From: Martyn White <Martyn.White@arun.gov.uk> **On Behalf Of** Conservation Officer
Sent: 21 November 2025 16:30
To: Planning.Responses <Planning.Responses@arun.gov.uk>
Cc: Harry Chalk <Harry.Chalk@arun.gov.uk>
Subject: P/124/25/PL

P/124/25/PL

Land to East of Commonmead Barn Pagham Road Pagham PO21 3PY

2 No single storey detached dwellings (with accommodation in the roof space) along with associated car and cycle parking (resubmission following P/9/24/PL).

Drawing Title:  
**PROPOSED BLOCK PLAN**

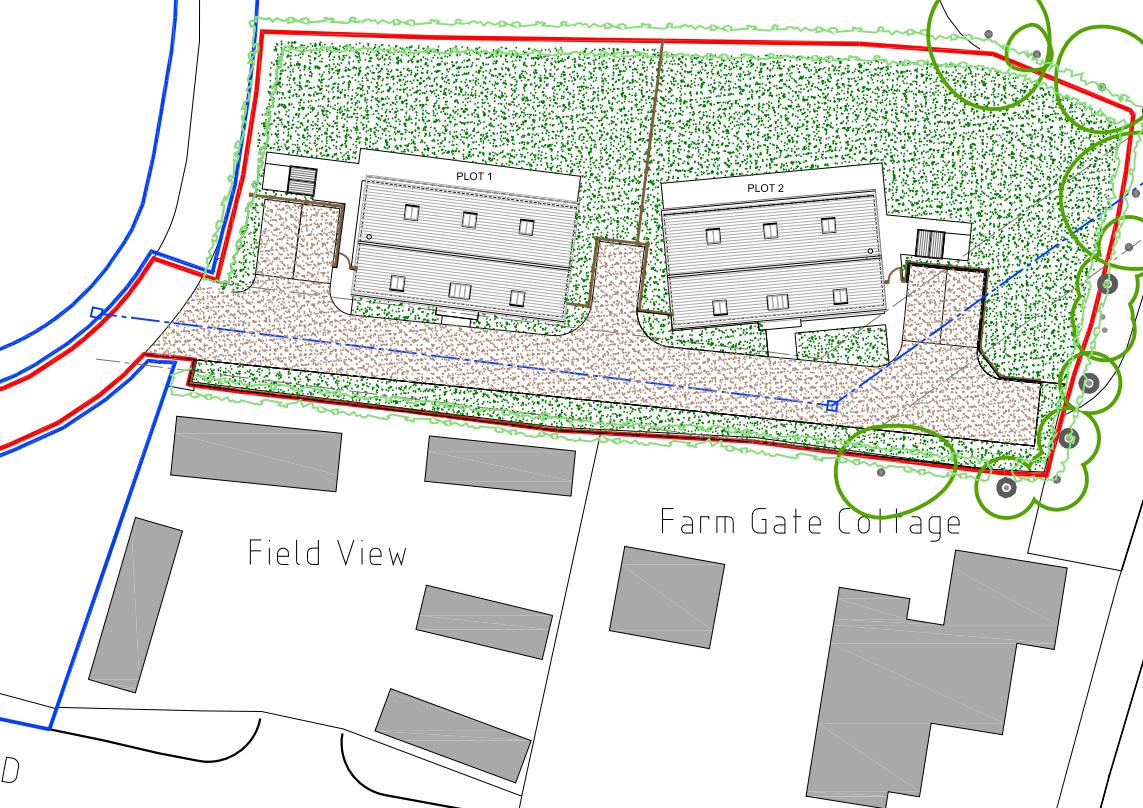
From the adjacent northern field, the principal elevation of the listed building is currently dominant. The introduction of new dwellings, particularly the one closest to the farmhouse, could alter this view, reducing the prominence of the heritage asset.

- Retention and enhancement of boundary planting.
- Additional hedging and buffer zone at the northeastern edges.
- Building placement to maximize distance from the listed building.

Additional planting is proposed in the form of new hedging to the northern part of the site. However, hedging alone may not provide effective long-term screening unless allowed to grow to a significant height, and its impact is therefore uncertain. Furthermore, there is no clear mechanism to ensure the retention of both existing and proposed boundary vegetation in perpetuity. Future occupiers could remove planting and replace it with fencing or other boundary treatments under permitted development rights, which would undermine the intended mitigation.

Drawing Title:
**PROPOSED ELEVATIONS AND SECTION
 PLOT 2**

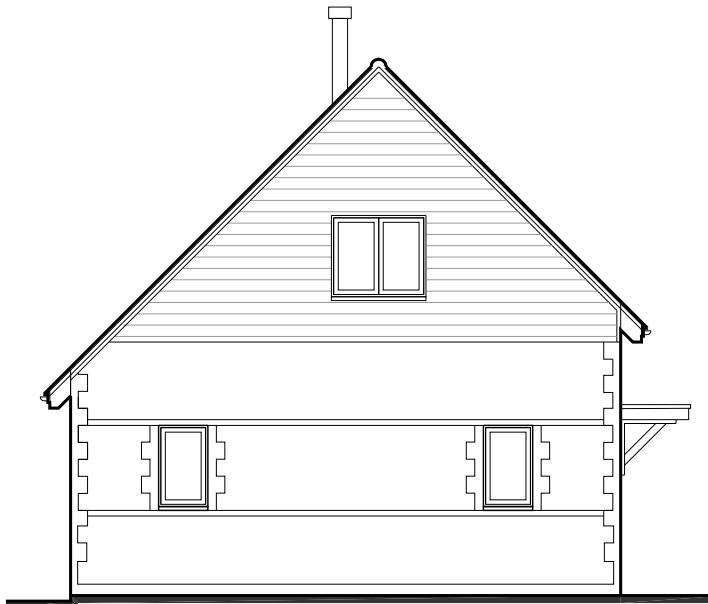
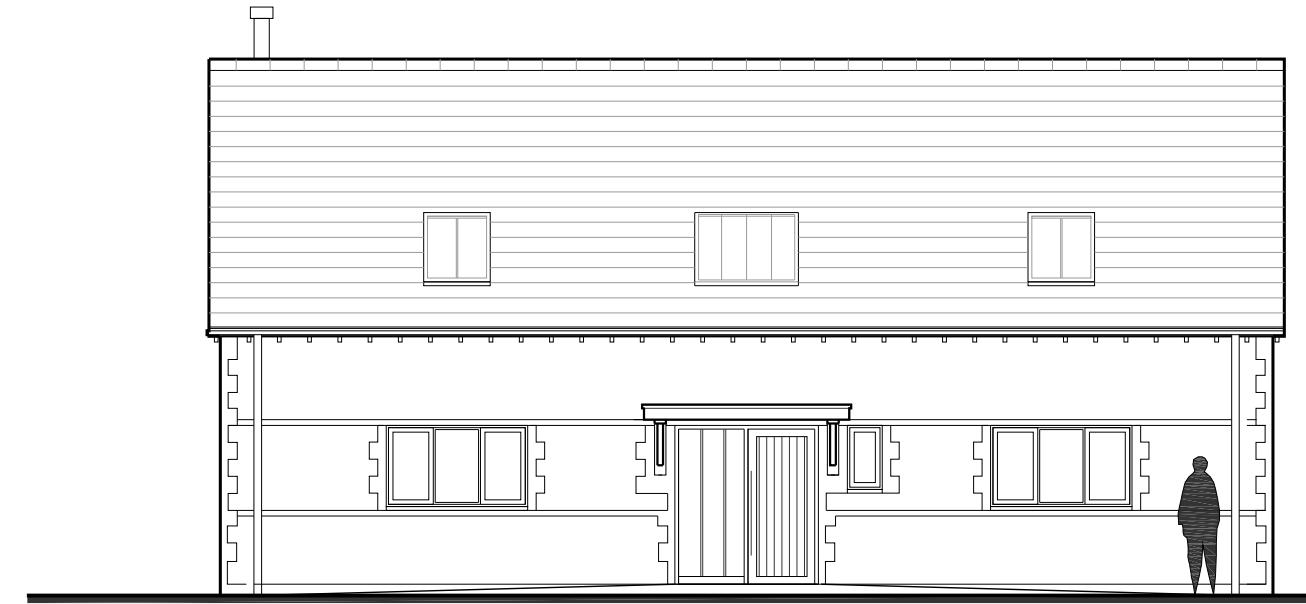
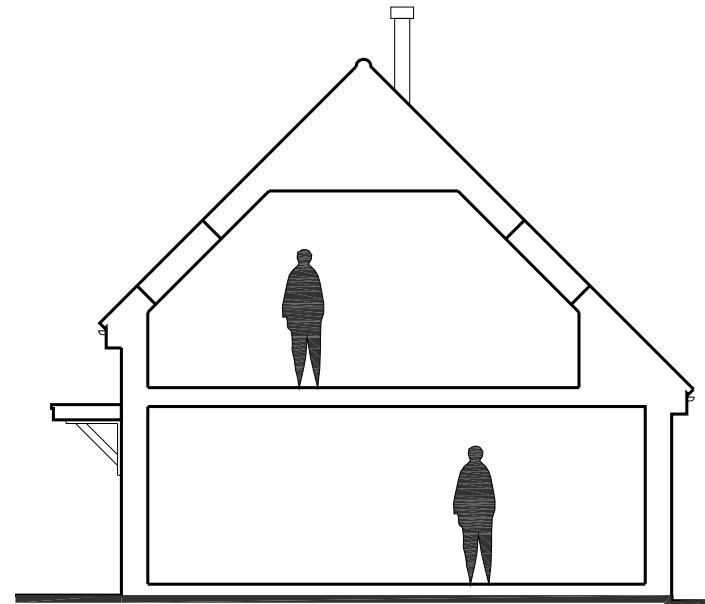
The applicant states that the design of the proposed dwellings draws inspiration from the neighbouring former farm buildings to the north. The intention is for the houses to adopt a simple, rural character and read as agricultural barn conversions rather than domestic cottages, as previously suggested. While the concept is understood and could help integrate the development into its historic context, its success is entirely dependent on the execution of detailing and materials.

The use of high-quality, traditional materials, such as flint cobbles (rather than modern flint blocks), timber-framed windows, and handmade clay roof tiles, is essential to achieve the intended aesthetic. These elements would help the buildings appear as part of the loose arrangement of former barns within the historic farmstead, rather than as suburban infill. Conversely, failure to secure these details would undermine the design approach and weaken its ability to mitigate harm to the setting of the listed building.

If approval is recommended, it is imperative that conditions are imposed requiring full details of all external materials, finishes, and construction techniques. This should include sample panels for flintwork, specifications for joinery, and roofing materials. Without such controls, there is a significant risk that the development will not deliver the rural character claimed and will instead introduce an incongruous suburban form into a sensitive historic setting. It should also be acknowledged that, regardless of material quality, the design will never match the architectural or historic significance of the heritage asset.
